A1/13770/91

**Construction of residential building
in Door No.28 at S.No.260/1 of
Kodambakkam Village - Approved -
Regarding.**

The proposal received in the reference cited for
**the construction of residential building (Ground Floor + First
Floor) at Door No.28, S.No.260/1 of Kodambakkam Village has been
examined and found approvable.**

FIRST FLOOR PLAN

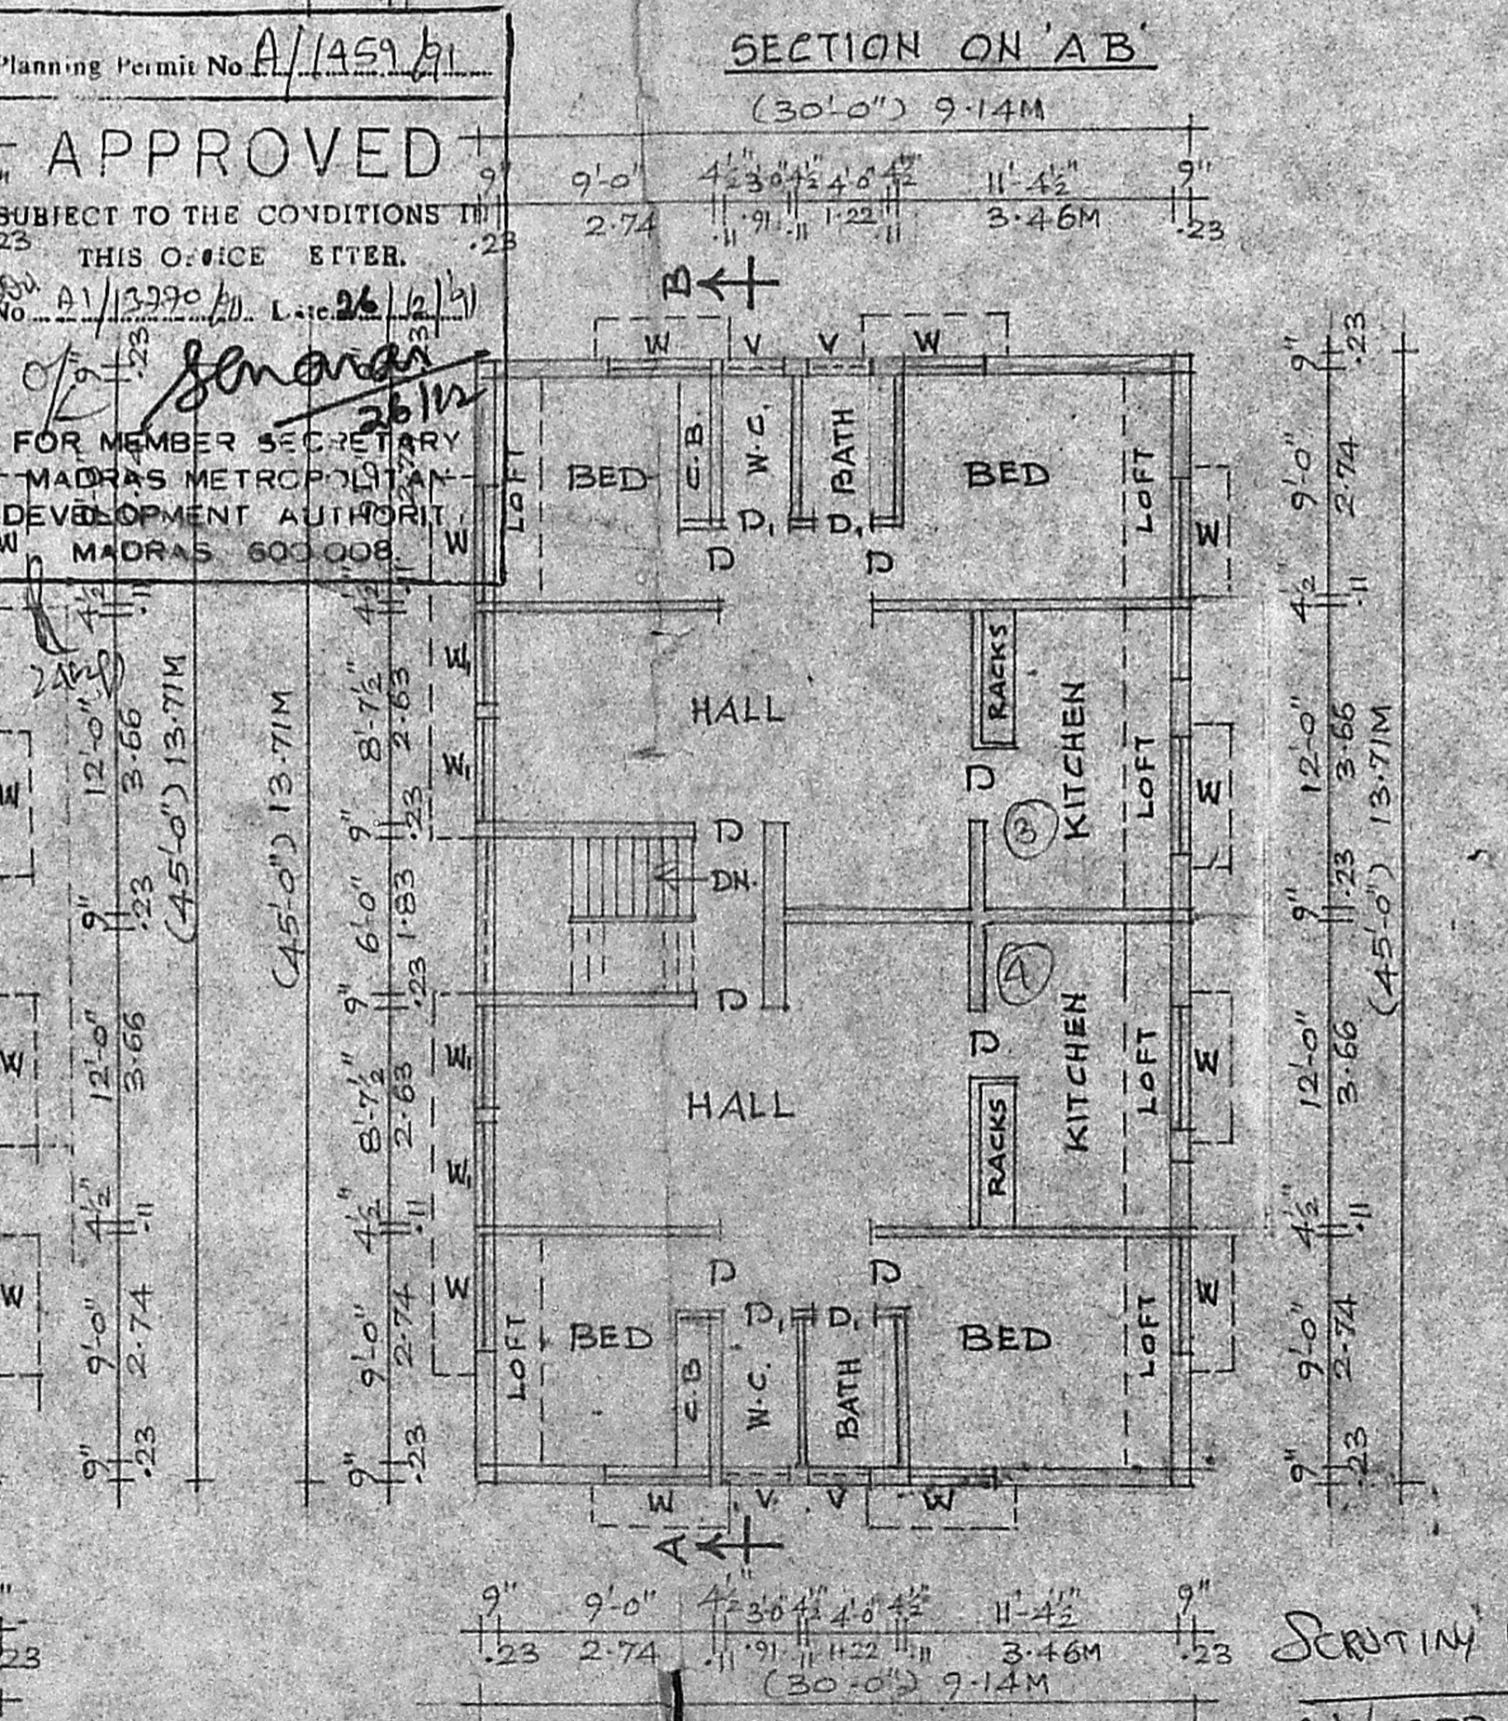
**Further you are requested to furnish
5 sets of revised plans mentioning the usage of the cantilever
projection in first floor signed by different class-I Licensed
Surveyor in plans and in form-'B' & Other forms.**
